Development Facilitation Team (DFT) – Review Comments

DRB Project No: PR-2020-003484 Date: 05/10/2023 Agenda Item: #4 Zone Atlas Page: E-10

Application For: SD-2023-00048 – PRELIMINARY PLAT (DHO)

DRB Project Number: 2020-003484 Hearing Date: **05-10-2023**
 Project: Mojave Ridge Subdivision Agenda Item No: **4**

PRELIMINARY PLAT FOR
MOJAVE RIDGE SUBDIVISION
 (A REPLAT OF LOTS 2 & 3, BLOCK 12,
 UNIT 3, VOLCANO CLIFFS SUBDIVISION)
 WITHIN
 SECTION 27,
 TOWNSHIP 11 NORTH, RANGE 2 EAST, N.M.P.M.
 CITY OF ALBUQUERQUE
 BERNALILLO COUNTY, NEW MEXICO
 DECEMBER, 2022

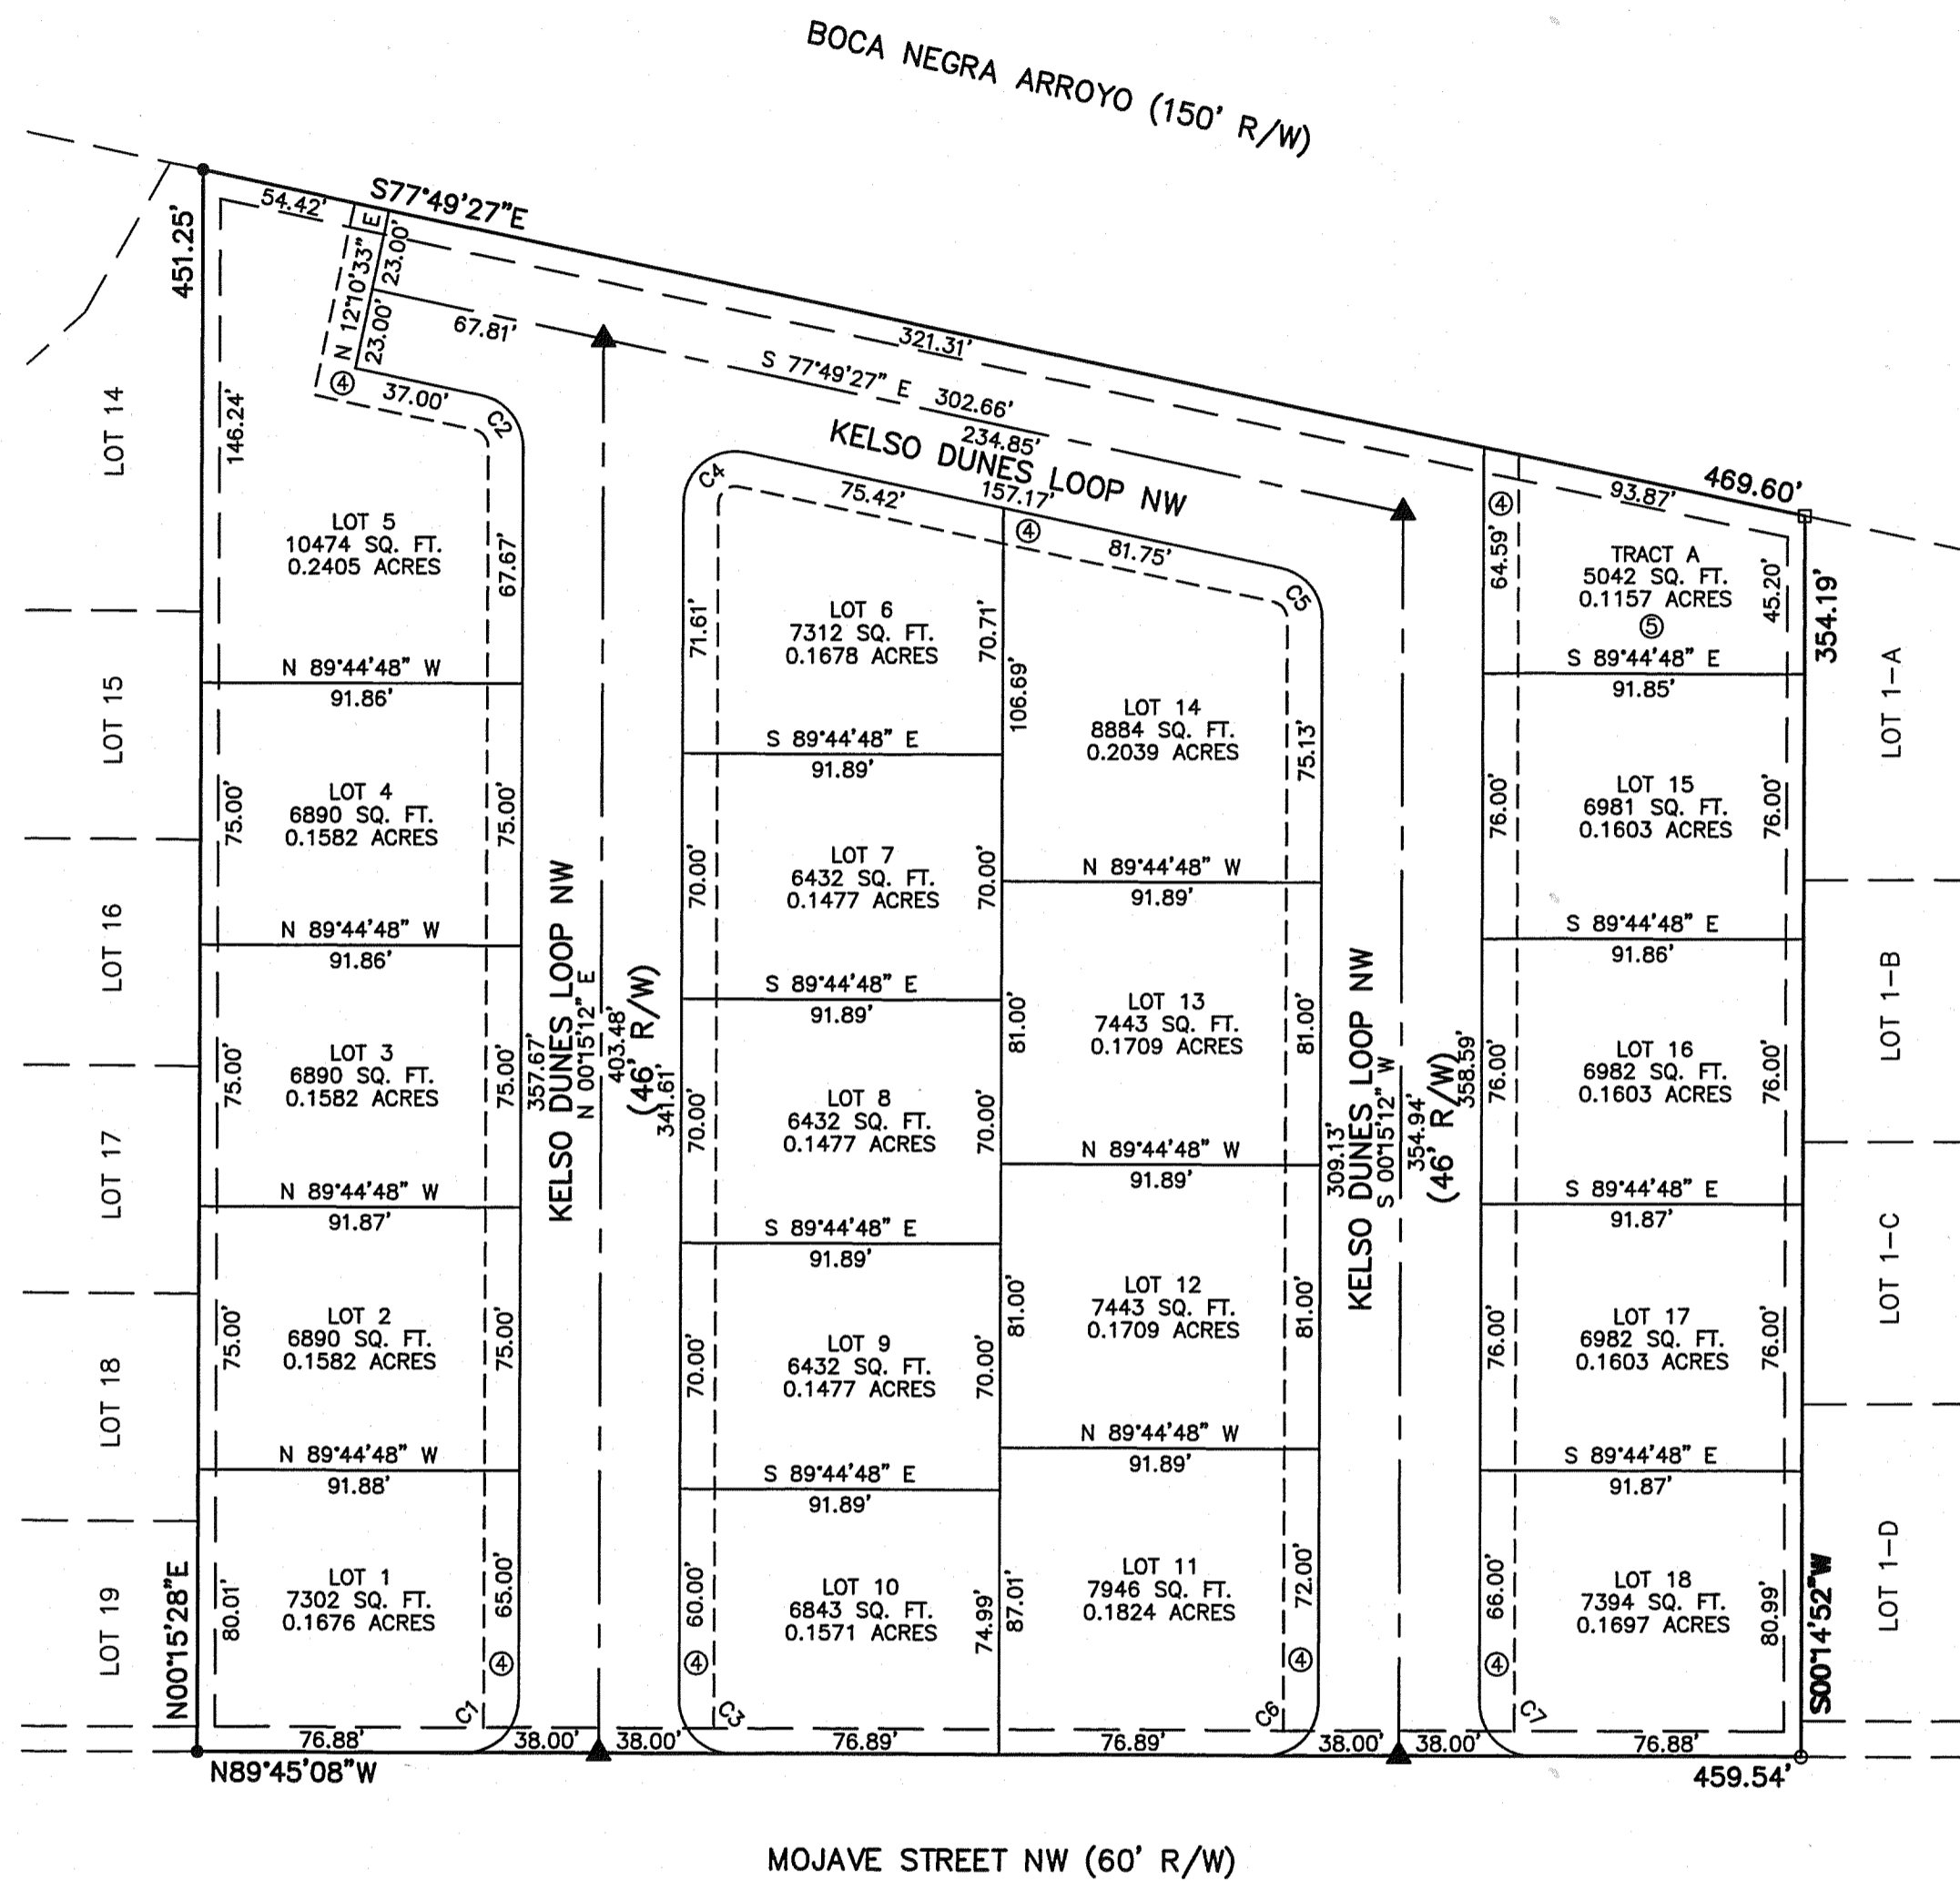
Change the maintenance note of Tract A (pond) to be the Homeowner's Association; city maintenance is not provided for Tract A.

CITY OF ALBUQUERQUE
 PUBLIC WORKS DEPARTMENT
 ENGINEERING DEVELOPMENT GROUP
MOJAVE SUBDIVISION
 GRADING AND DRAINAGE
 GRADING PLAN

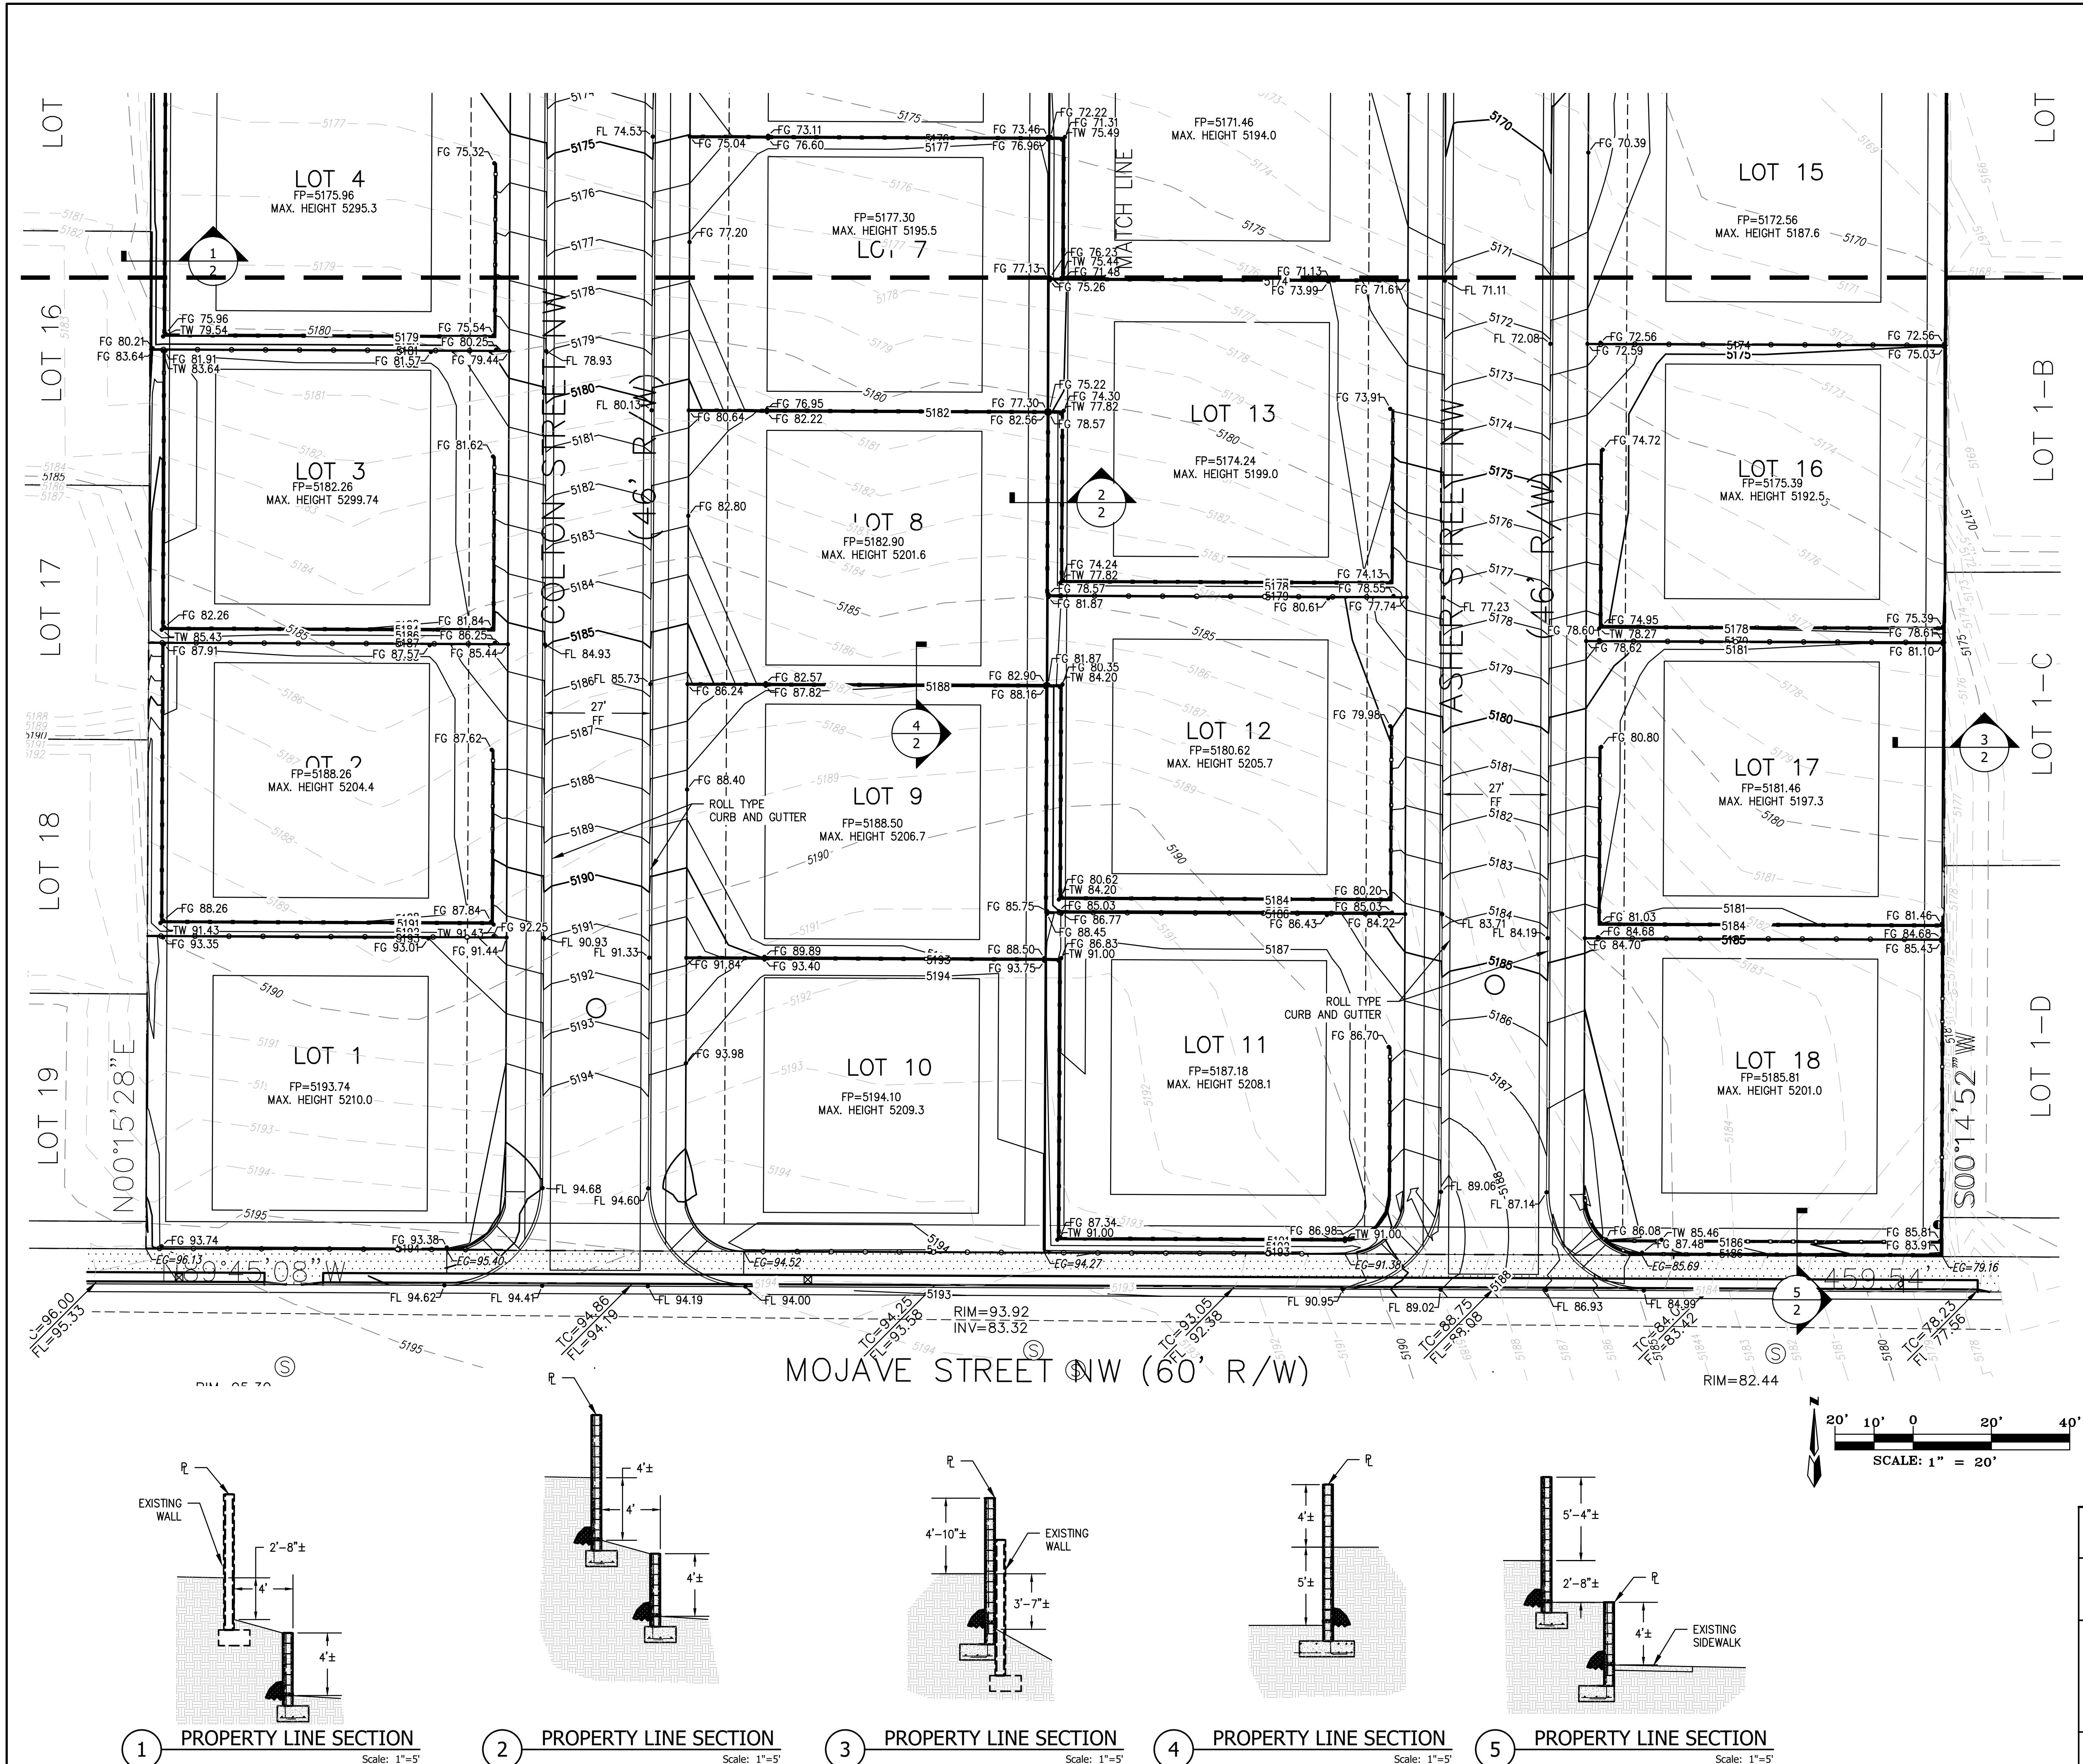
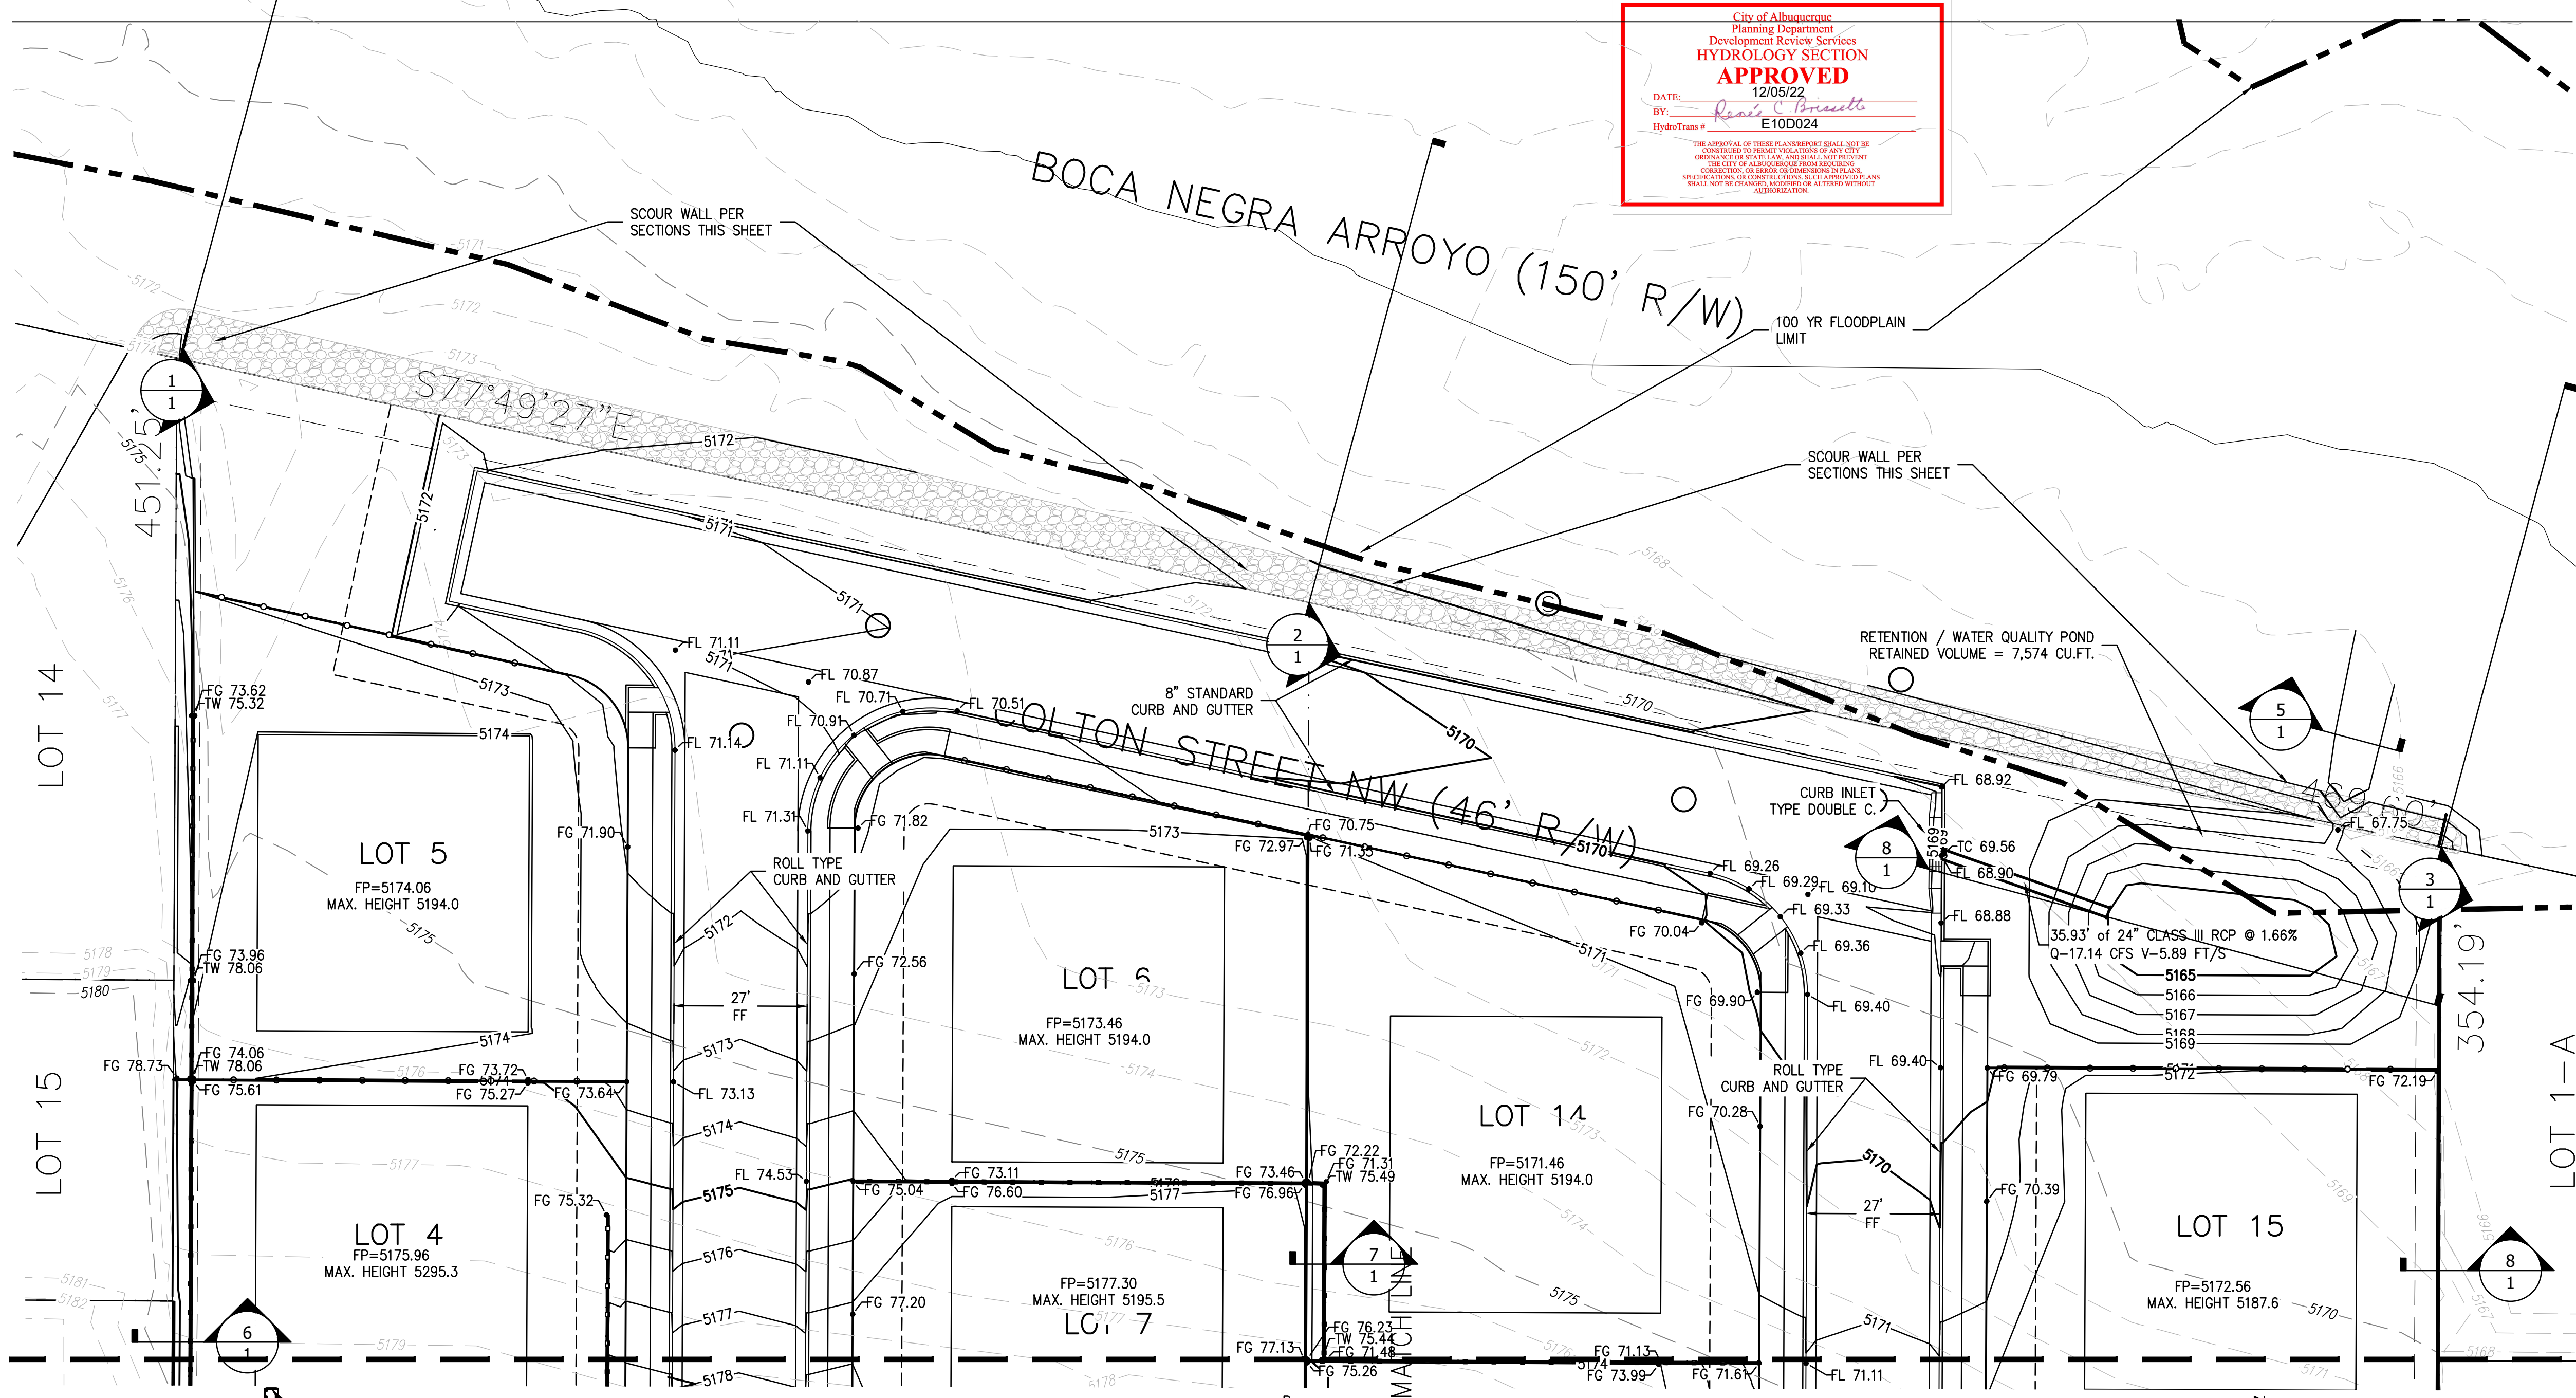
- **IDO 3-6(E) The parcels are in the VPO-2 Height Restricted Sub Area. Identify the allowable structure height vis a vis grading plan.** 'Building and/or structure height shall not exceed 15 feet, as measured from natural grade.'

***Show height measurements from finished grade and natural grade. *Clarify if standards are being met.**
